Application by Augean South Limited for East Northants Resource Management Facility Western Extension

The Examining Authority's Written Questions and Requests for Information (ExQ2)

Issued on 27 April 2022

Figure ESA5.1 Scale: 1:2,500@A2

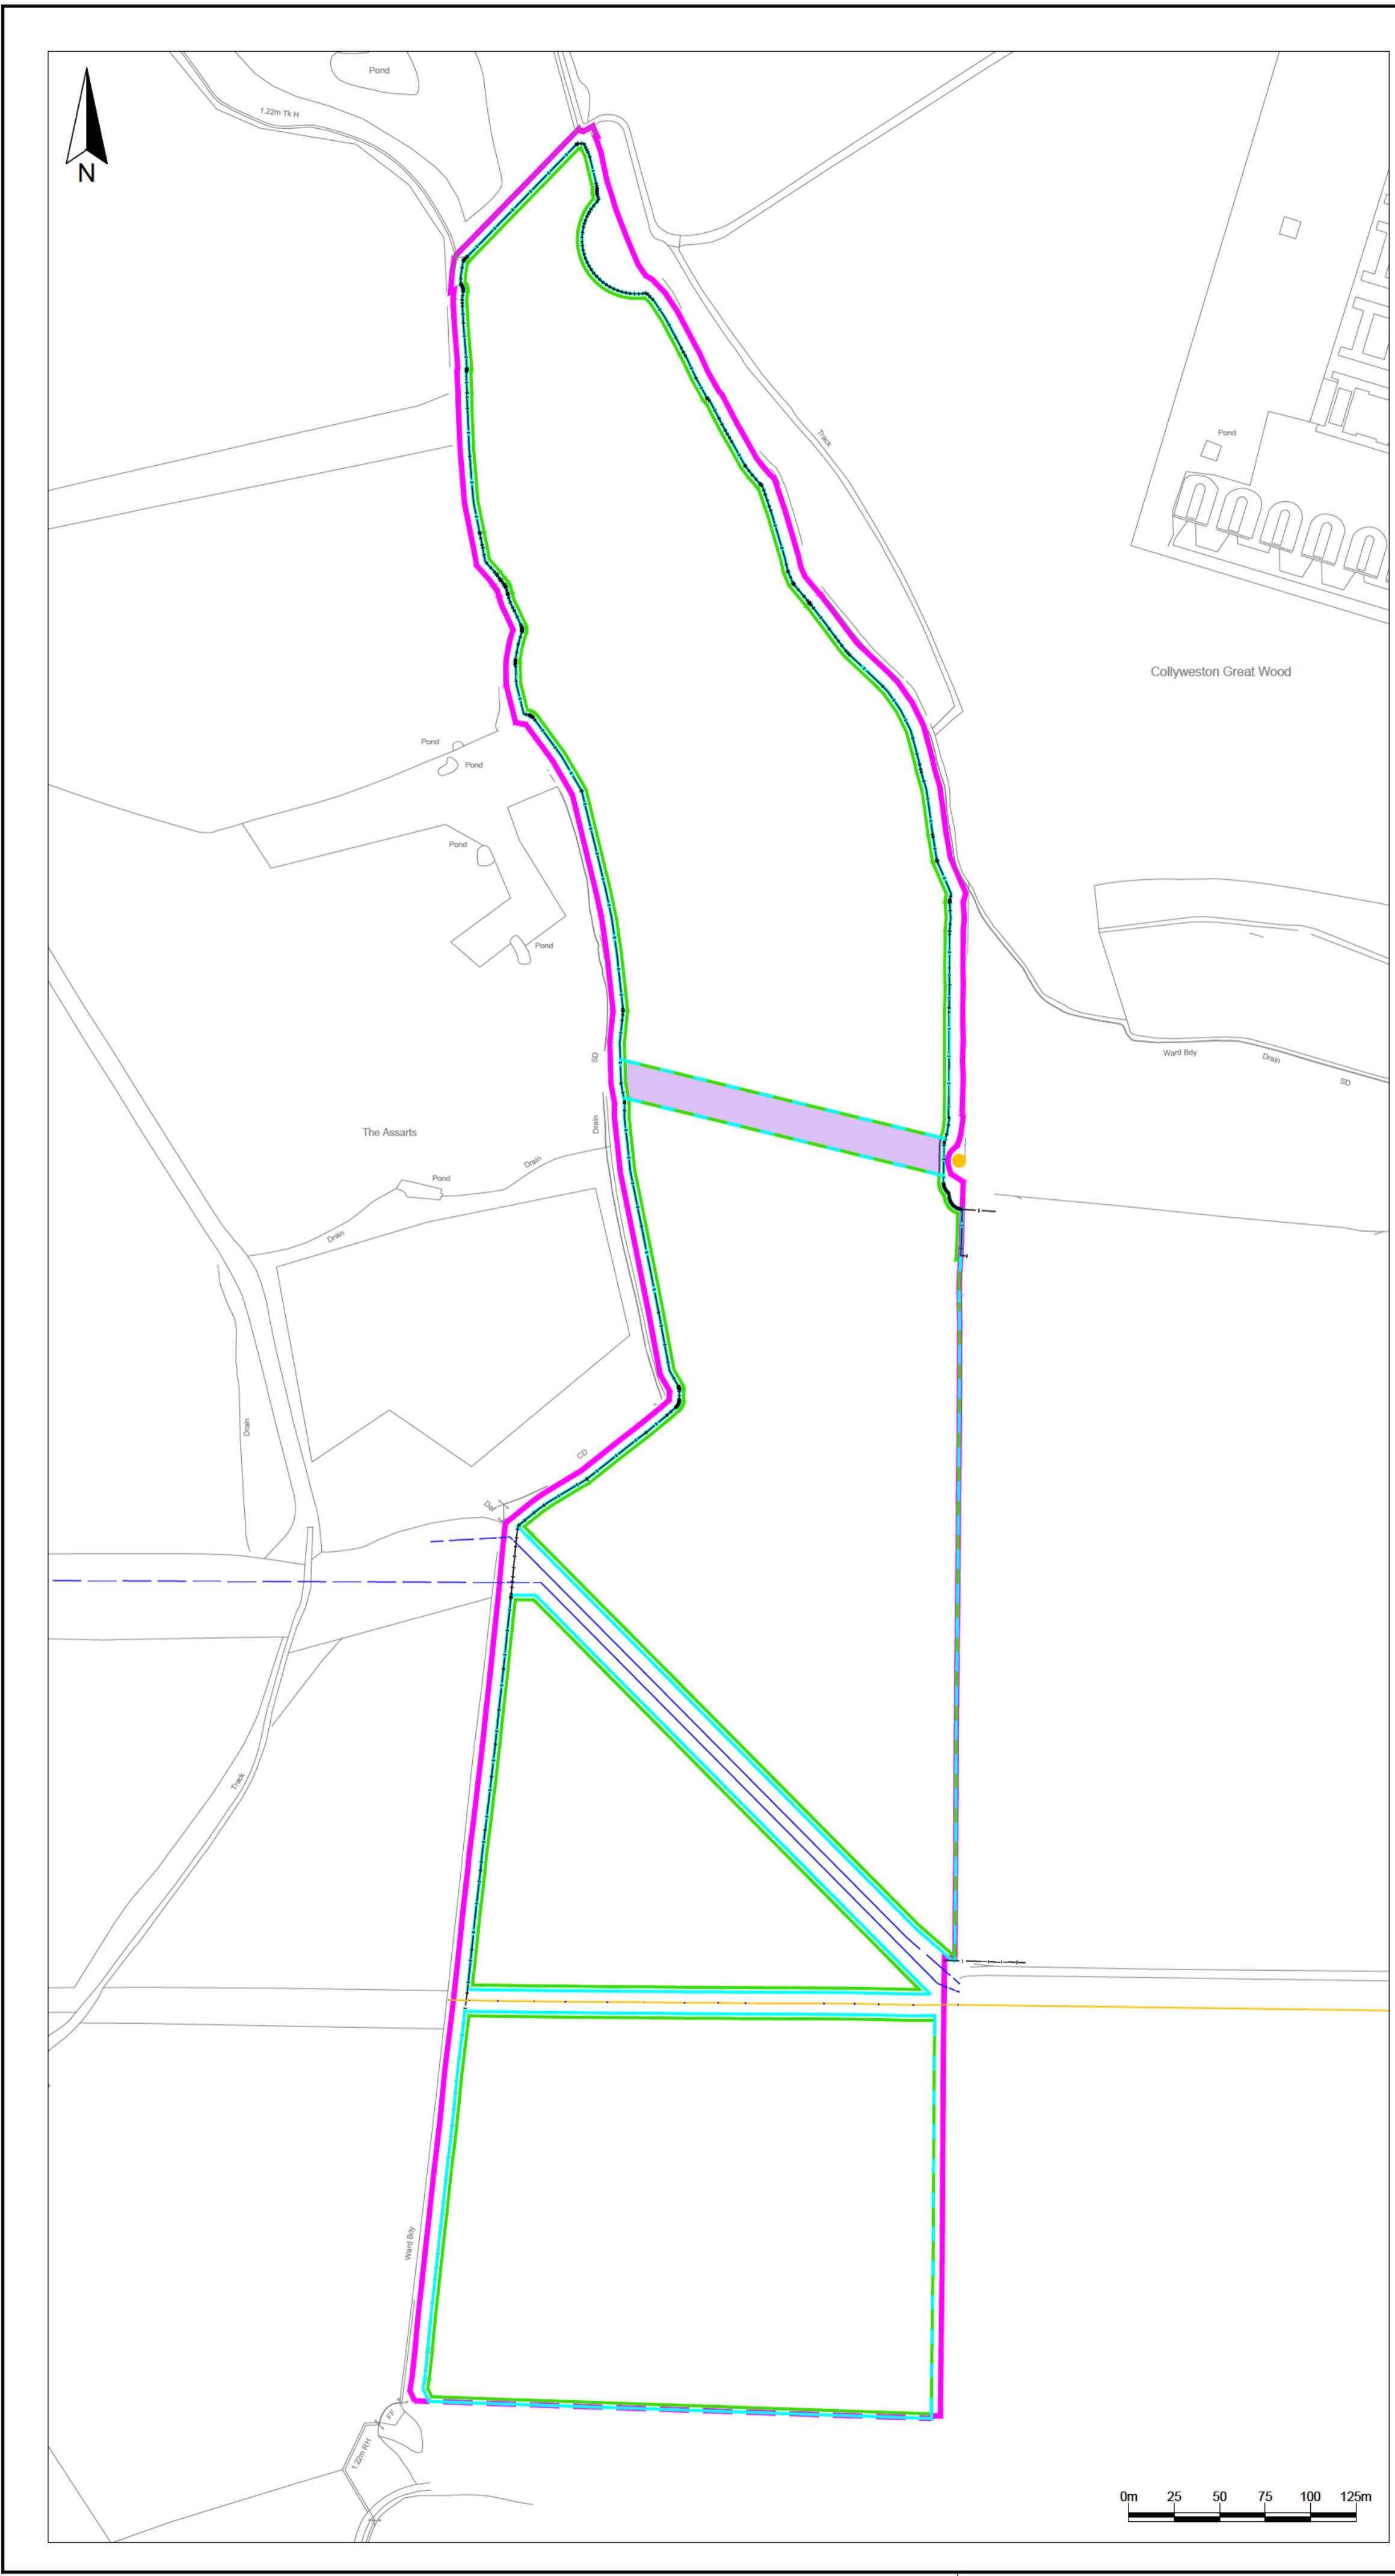
ExQ2	Question to:	Question:
4.	Landscape and Visual	
Q4.1	The Applicant	In response to the queries raised in ExQ1 and ISH2, [REP4-006] includes further assessments of the landscape and visual effects of Works 2 and 3. The assessment of Work 2 appears to be based on the parameters set out on the dDCO [REP4-004] and DEC Appendix DEC D [APP-110] and, therefore, accords with the Rochdale envelope approach to EIA assessment. The assessment of Work 3 still appears to be based on the premise of individual building of similar scale to the existing buildings being constructed under the dDCO. Whilst this may be the most likely scenario, the assessment does not take into account the full effect of the potential development which would be permitted under the parameters set out in the dDCO and the DEC (that is 8m tall structures covering the whole of the Work 3 area). Please respond by means of a further assessment or revision to the parameters for Work 3.
